A12 Chelmsford to A120 widening scheme

8.16 Statement of Common Ground with Witham Town Council

Statement of Common Ground with Witham Town Council

STATEMENT OF COMMON GROUND

Drawing title: **ENVIRONMENTAL STATEMENT ENVIRONMENTAL MASTERPLAN CH. 19600/20000 TO 21400 SHEET 8 OF 21**

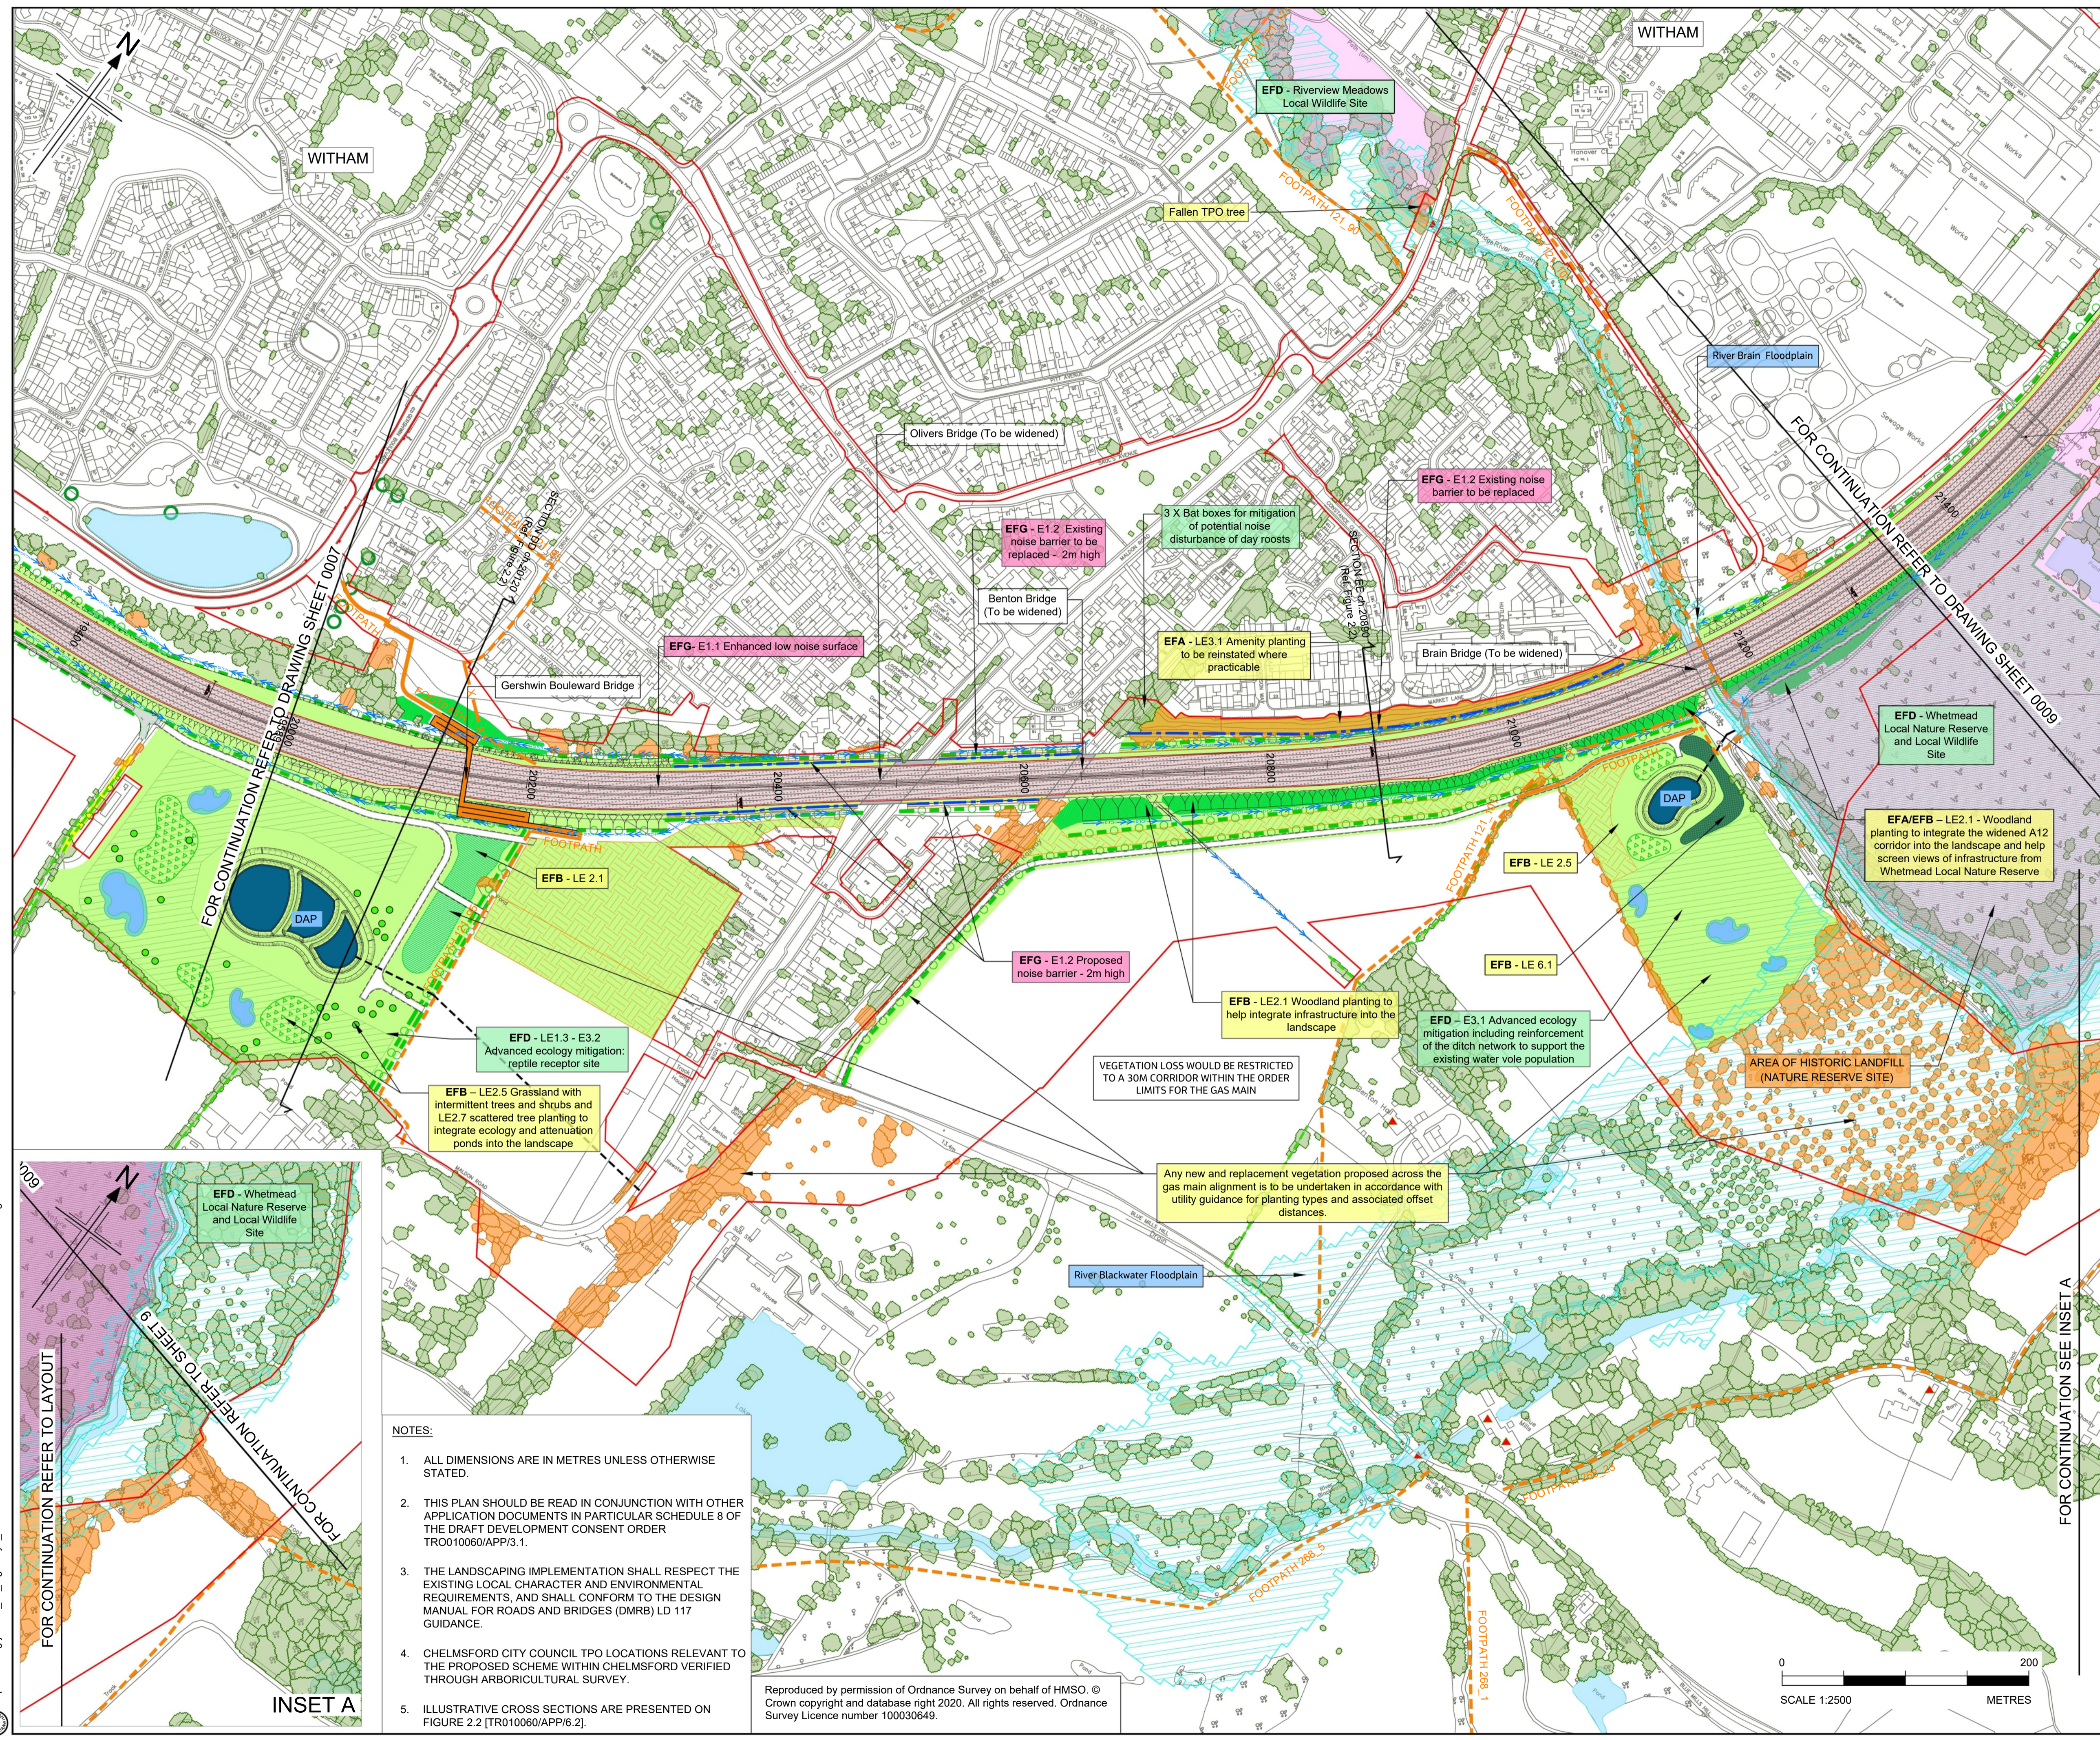
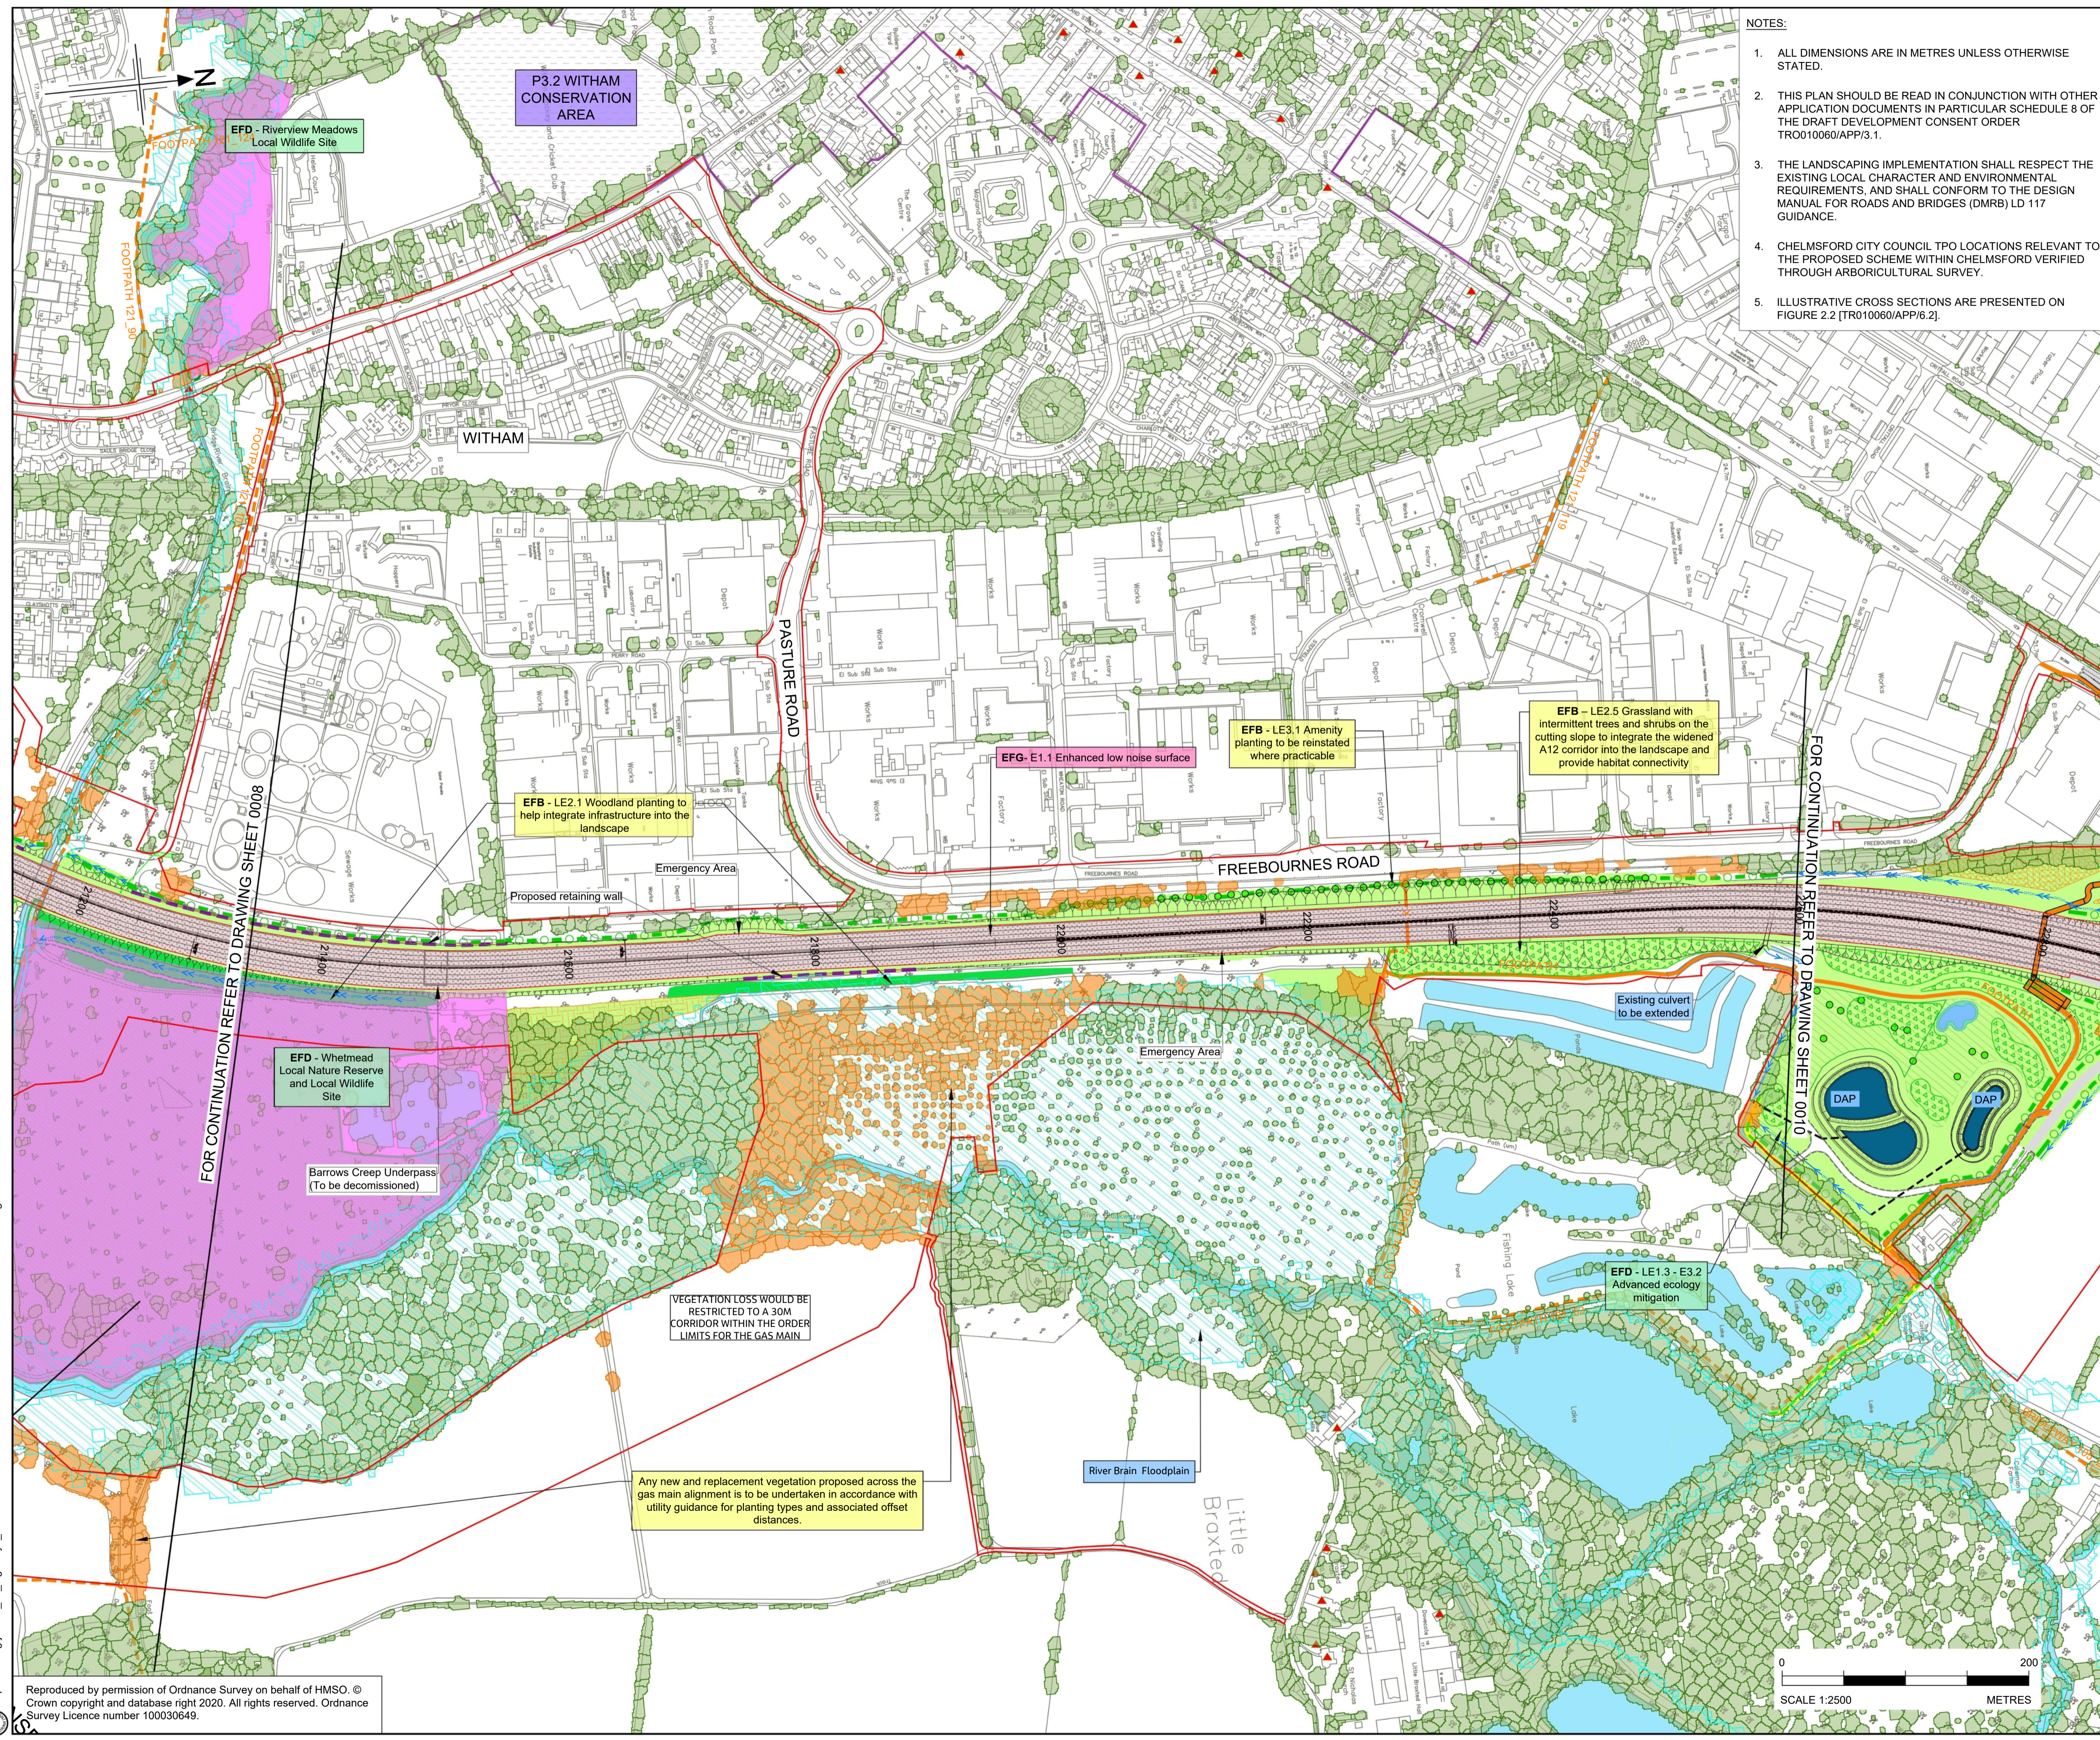
Ref	Issue	Doc Reference	Witham Town Council Position	National Highways Position	Status	Date
				between National Highways and Witham Town Council, and allow for input into and review of plans, restrictions and closures affecting local communities to be discussed. The inclusion of Witham Town Council in the forums will allow concerns to be raised and discussed prior to any proposed diversions, restrictions or closures being implemented. Refer to Table 3.1 of the OCTMP [REP6-054].		
5	Operational noise	Environmental Statement, Chapter 12, Noise and vibration [APP-079] Environmental Statement, Figure 12.8 Noise Change Contour Map Sheets 4 and 5 [APP-235]	<i>Concerns that road noise from operational A12 will adversely affect residents. The expansion of an existing two lane dual carriageway to a three lane dual carriageway leads to the anticipation of greater operational noise of the road upon the completion of the construction works.</i>	Reduction of noise at source, is the most effective mitigation measure. Enhanced low noise surfacing is proposed between a point east of the new junction 21 and to the east of the new junction 22. This enhanced low noise surfacing has better noise reducing properties than conventional low noise surfacing and ensures the benefits of the enhanced low noise surfacing to the community of Witham. Refer to Environmental Masterplans Part 1 (sheets 6, 7 and 8) [REP6-043] and Part 2 (sheets 9 and 10) [REP6-044].	Agreed	31/05/2023

Ref	Issue	Doc Reference	Witham Town Council Position	National Highways Position	Status	Date
				communicate with local residents would be set up to highlight potential periods of disruption through the construction phase. This commitment, PH1, can be found in Appendix A: REAC [REP6-052] of the first iteration Environmental Management Plan.		
7	Loss of mature Trees and Shrubs	<p>Environmental Statement, Chapter 9, Biodiversity [APP-076]</p> <p>Retained and Removed Vegetation Plans, Part 1 [REP6-032] and Part 2 [REP6-033]</p> <p>Environmental Statement, Chapter 3, Assessment of Alternatives [APP-070]</p> <p>First iteration Environmental Management Plan (EMP) Appendix A: Register of Environmental Actions and</p>	<p><i>Loss of mature trees and shrubs</i></p> <p><i>WTC are happy subject to the assurance that wherever possible, no mature or semi mature tree will be removed unnecessarily.</i></p>	The Applicant acknowledges that construction of the Scheme would result in adverse impacts to Whetmead Local Nature Reserve and Local Wildlife Site through the permanent loss of 0.89ha of semi-natural broadleaved woodland habitats adjacent to the A12 on the western boundary of the nature reserve. This loss would occur during site clearance to enable widening of the existing A12 carriageway and construction of a retaining wall. This would be mitigated through provision of approximately 2ha of new habitats in an area immediately south of and outside the existing Whetmead Local Nature Reserve site as detailed in Section 9.10 of Chapter 9: Biodiversity, of the Environmental Statement, [APP-076] and shown on sheet 8 of 21 of the Environmental Masterplan – Part 1 [REP6-043].	Agreed	31/05/2023
